# CITY OF PORTLAND, MAINE

July 22, 2015

Project Name: **Bangor Savings Bank Bank/Office building with two lane drive-through**  
Project ID: #2015-080  
Address: 20 Marginal Way CBL: 113 A 025001  
Applicant: Wendy Durrah, Bangor Savings Bank  
Planner: Jean Fraser

# PLANNING BOARD REPORT PORTLAND, MAINE

AE203

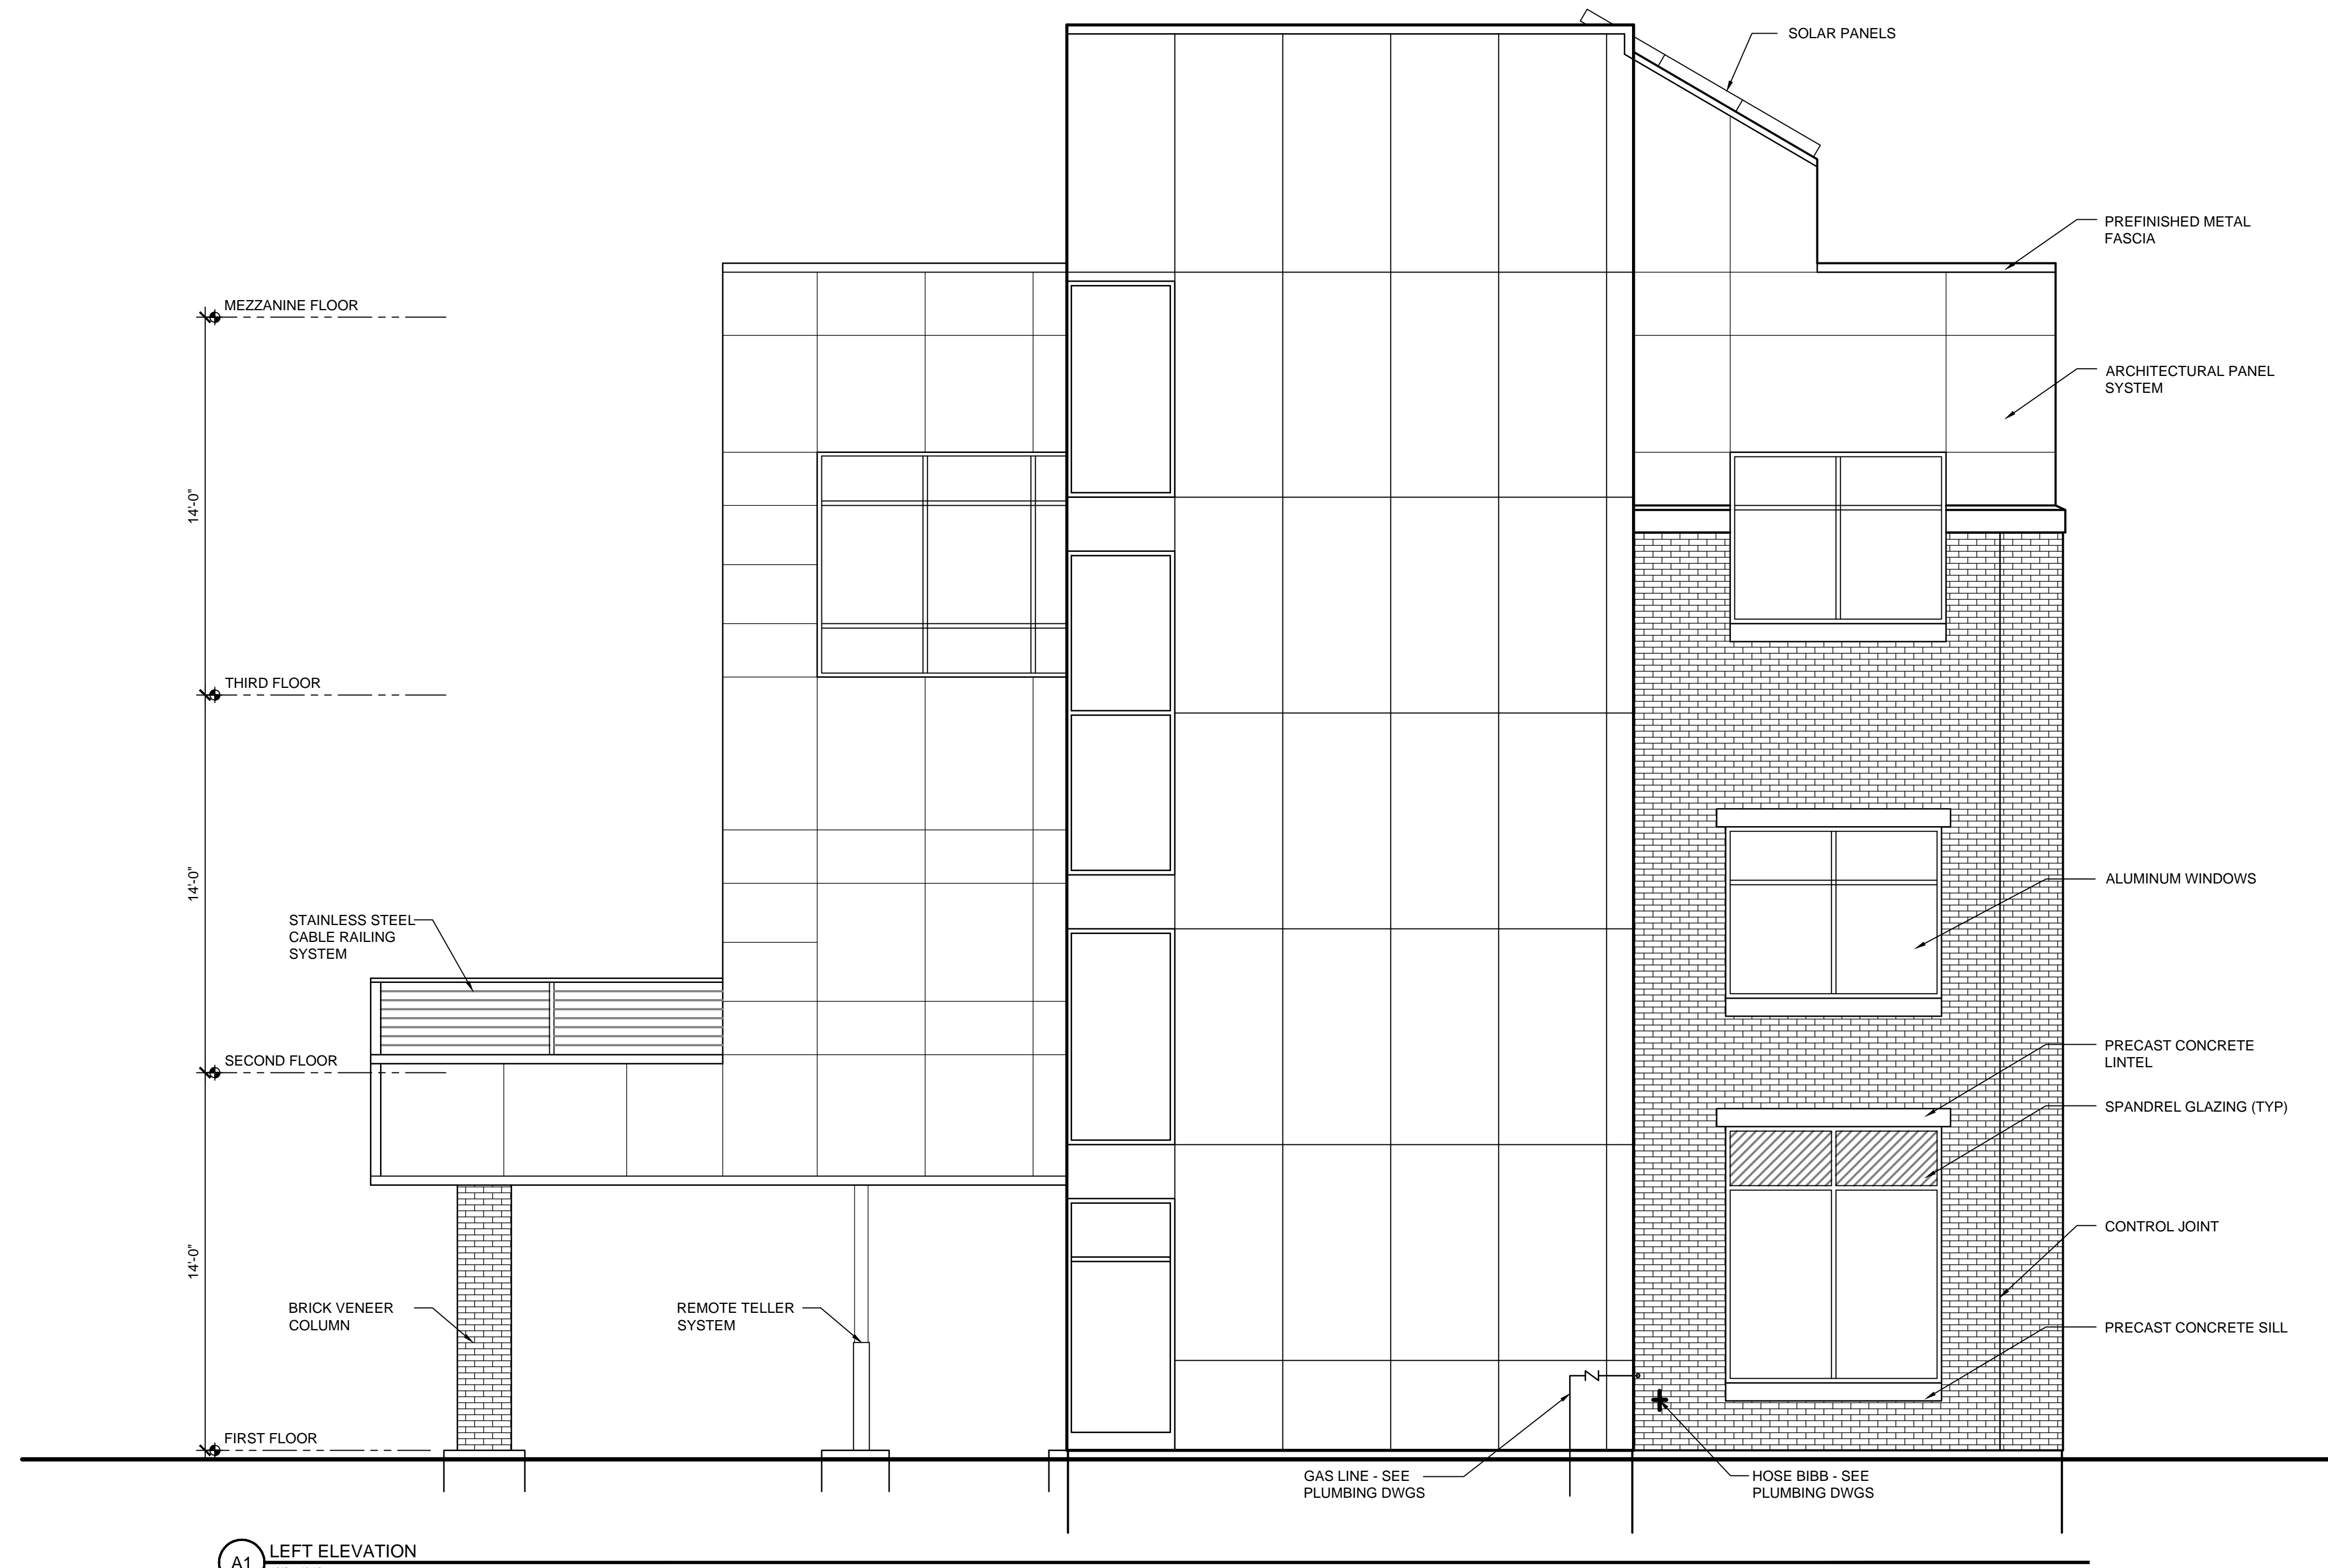
- **Proposed glass has a VLT of .56 which is lower than the allowed .7. A sample is required** before staff can assess whether the transparency is adequate.
- **Spandrel glass (opaque) is proposed** for the upper portion of the ground floor storefront which is **not allowed by the Standard. See comments below.**

- **Proposed transparency does not meet the Standard.**
- **Spandrel glass (opaque) is proposed** for the upper portion of the ground floor storefront **which is not allowed by the Standard. Staff does not support the use of spandrel glass in this project. Staff recommends that the ground floor windows be reduced in height** (and the canopy subsequently lowered) and the area where spandrel glass is proposed be eliminated. Reducing the amount of glazing will also reduce the solar gain in the façade.

- **Proposed glass has a VLT of .56 which is lower than the allowed .7. A sample is required** before staff can assess whether the transparency is adequate.
- **Proposed glass has a green tint** which is not allowed by the Standard. **Glazing should look clear. A sample is required** before staff can assess whether the color is adequate.
- **Spandrel glass (opaque) is proposed** for the upper portion of the ground floor storefront **which is not allowed by the Standard. See comments above.**

- ii. That the Planning Board has established that the maximum level of parking is 24 parking spaces; and
- iii. That the applicant shall reconsider the window design, including transparency, color, and size, in consultation with the City's Urban Designer, to meet the intent of the B-7 Design Principles and Standards. The final design to be reviewed and approved by the Planning Authority prior to the issuance of a building permit; and

Drawing file: Post Approval / As approved ES101-SitePhotometric.pdf

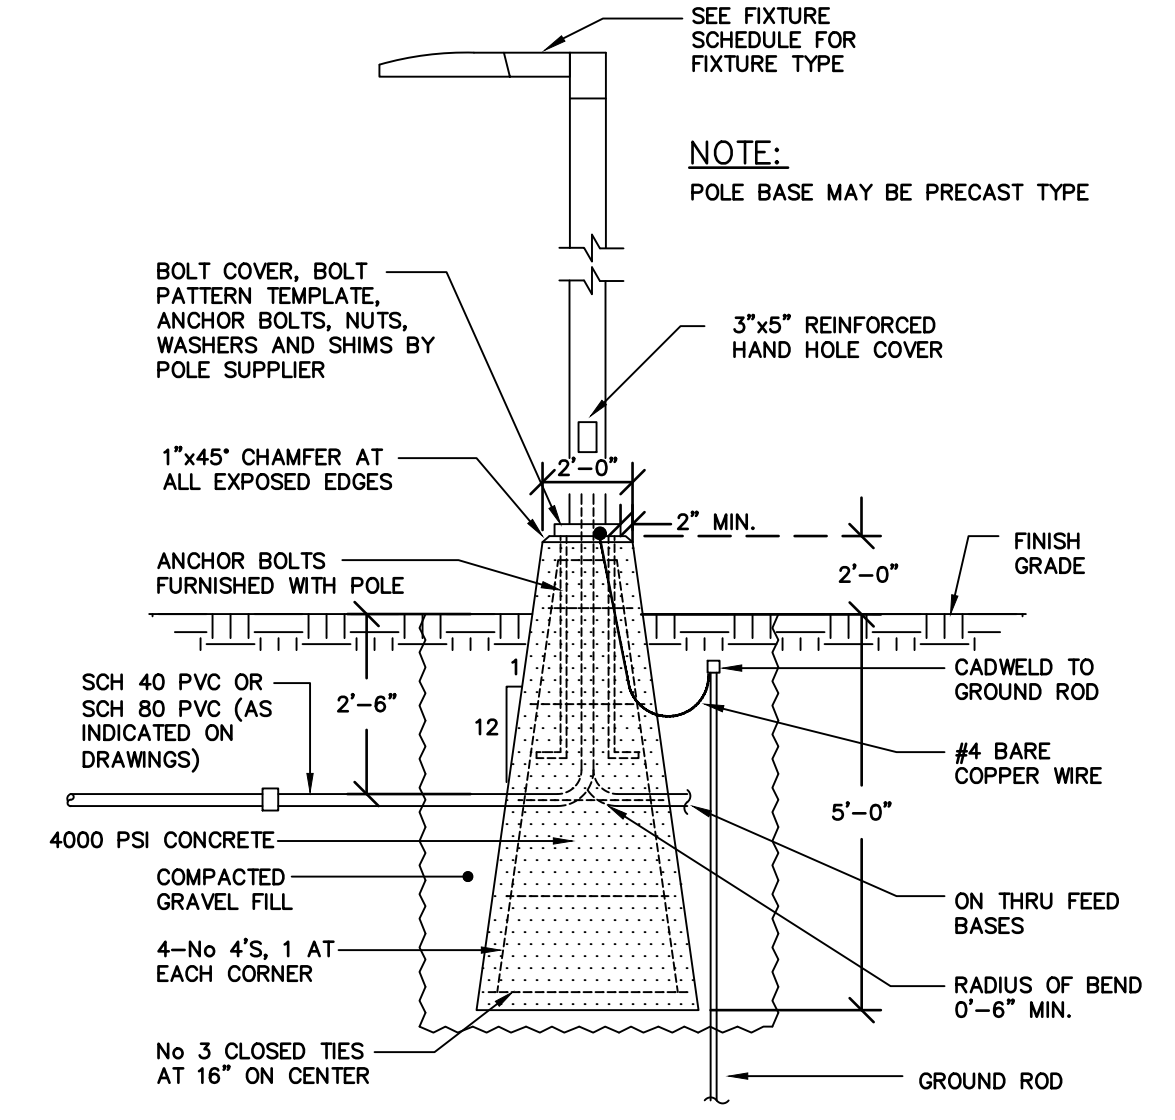
- viii. That the applicant shall submit, for review and approval by the Planning Authority prior to the issuance of a building permit, a revised photometric plan for the rear parking lot area that includes the lighting fixture specification, reduces trespass along the eastern boundary to meet Technical Standards, and increases the lighting levels in the vicinity of the drive-through; and
